sidewalk to MMC garage

Zack Barowitz <zbarowitz@gmail.com>

Tue, Jul 10, 2018 at 6:24 PM

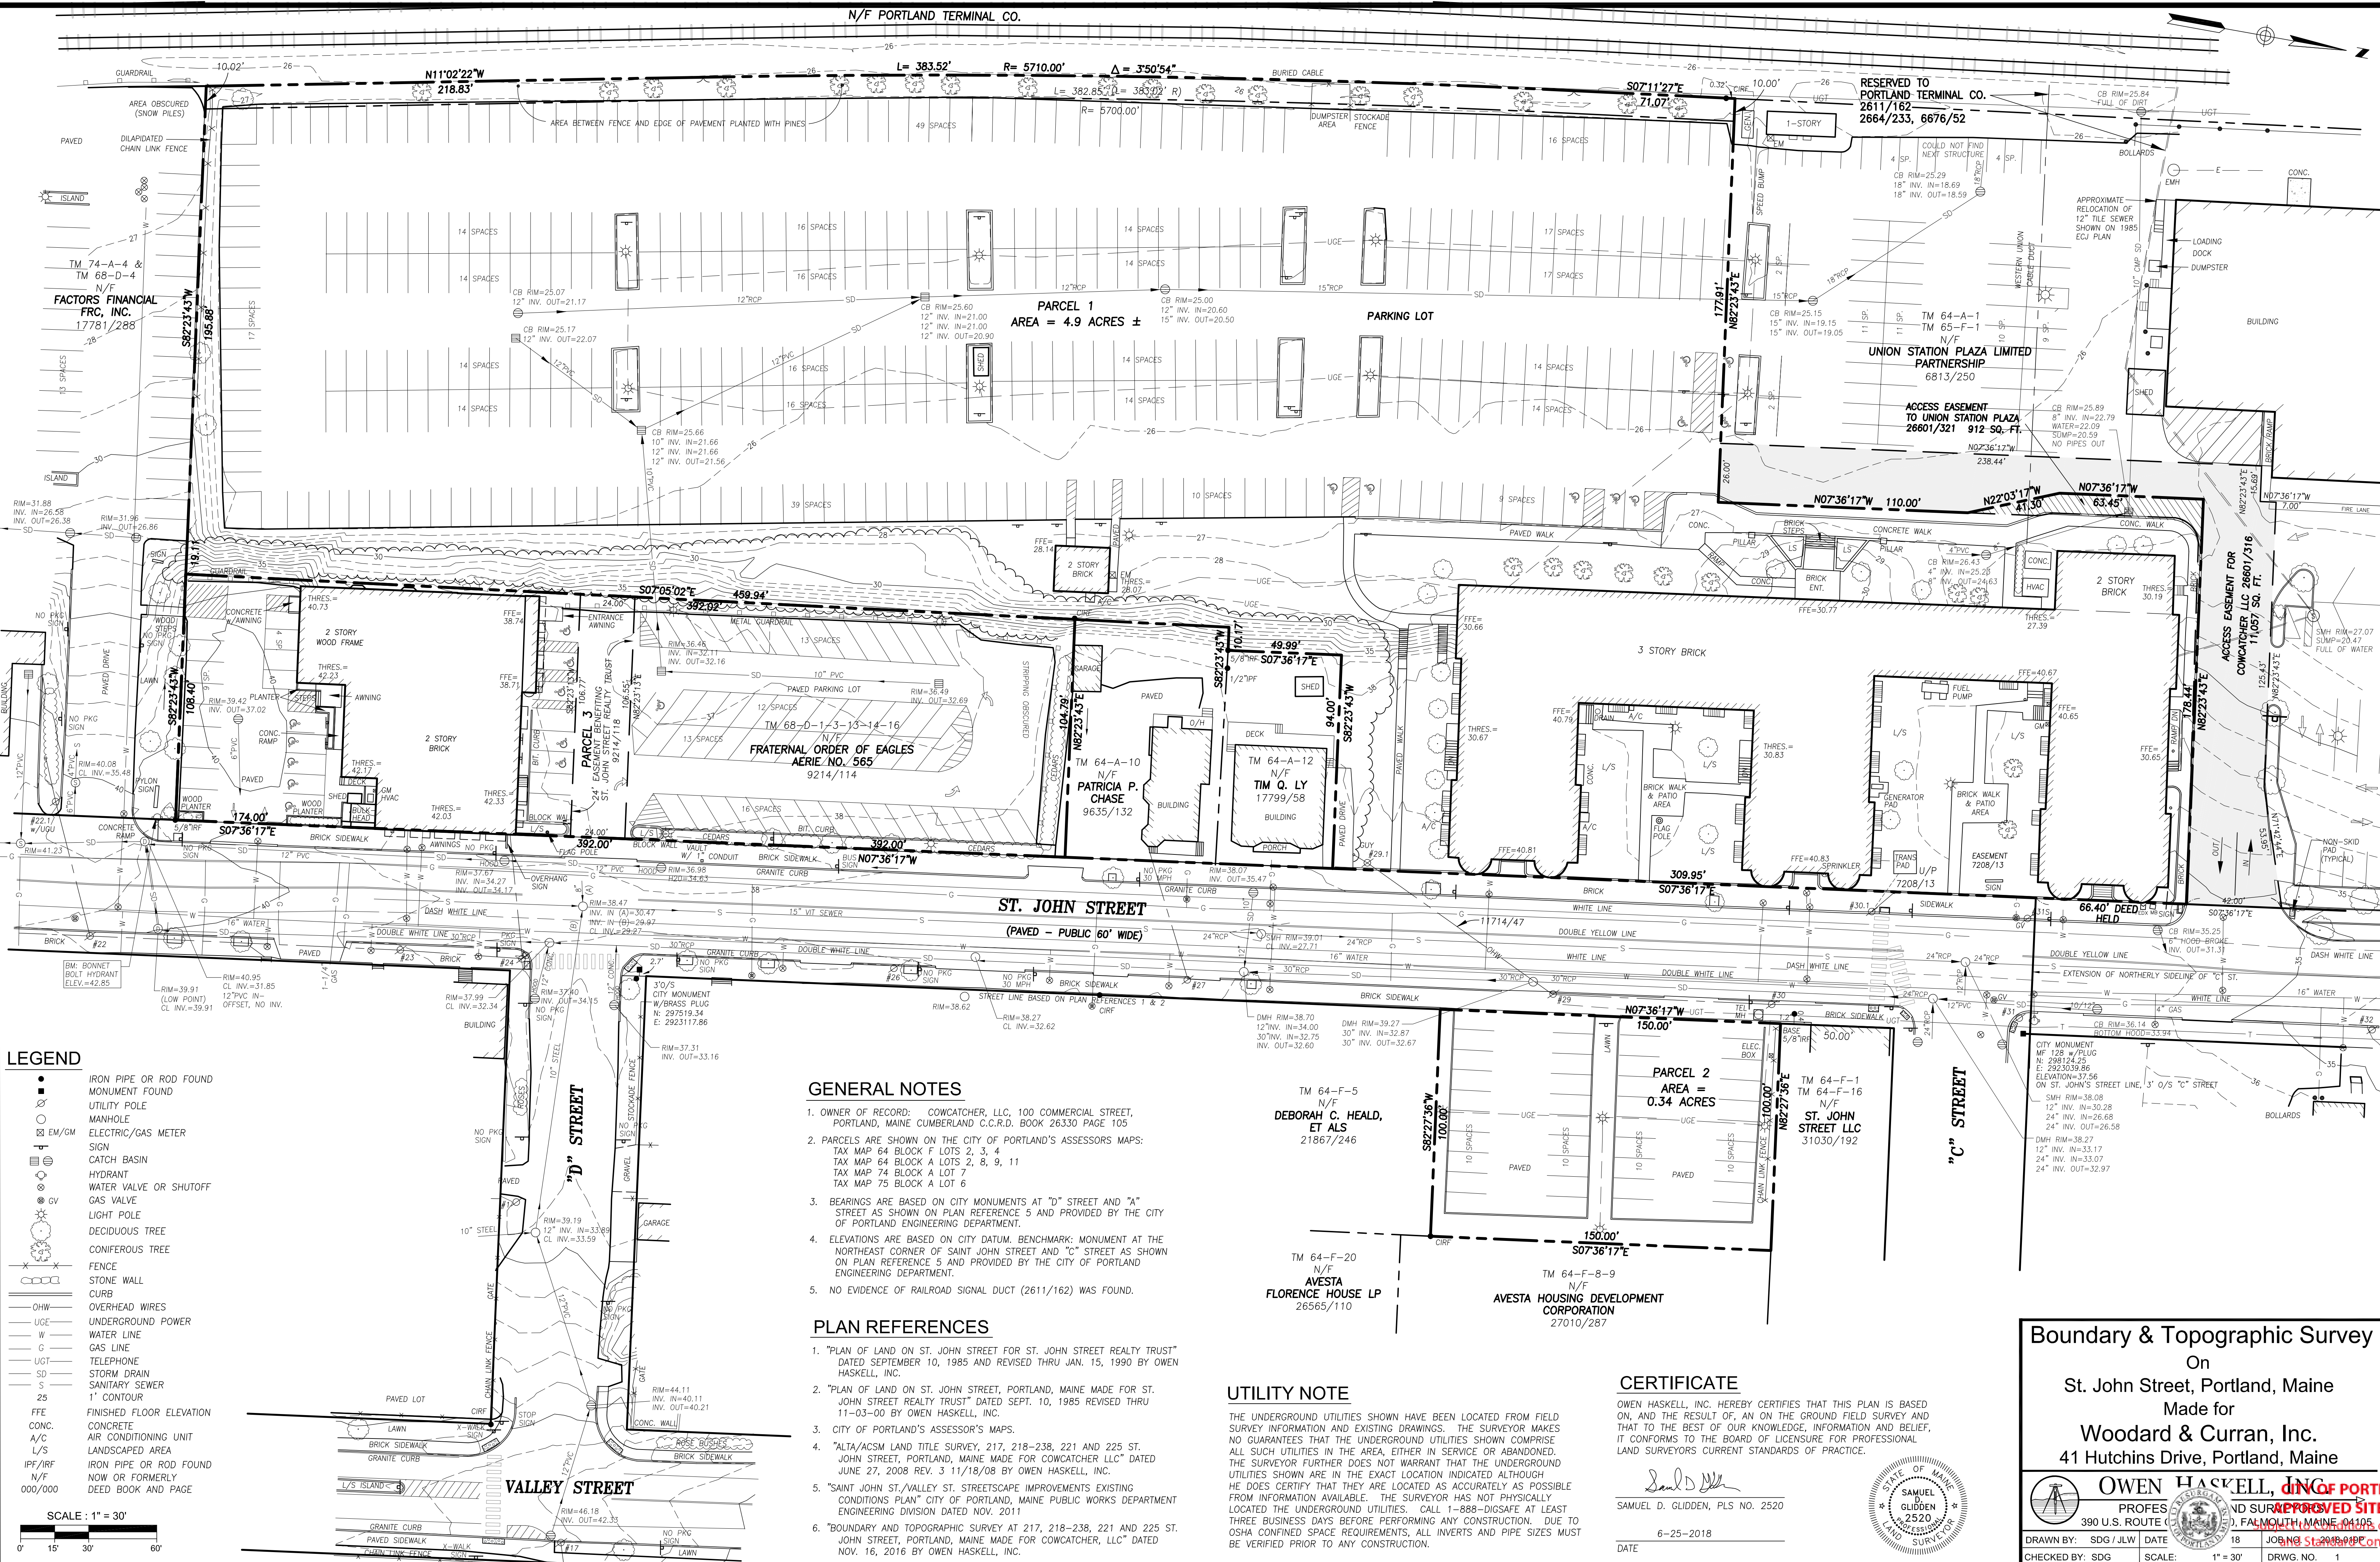
I noticed on one of the renderings of the front of the proposed MMC garage that there is a large open grassy space to the right of the driveway but only a narrow strip of paved sidewalk on the left side (when facing the garage). I'd like to see those spaces evened out a little bit, a wider sidewalk with a row of trees on the side would make a great difference. The sidewalk as rendered does not look pleasant for pedestrians.
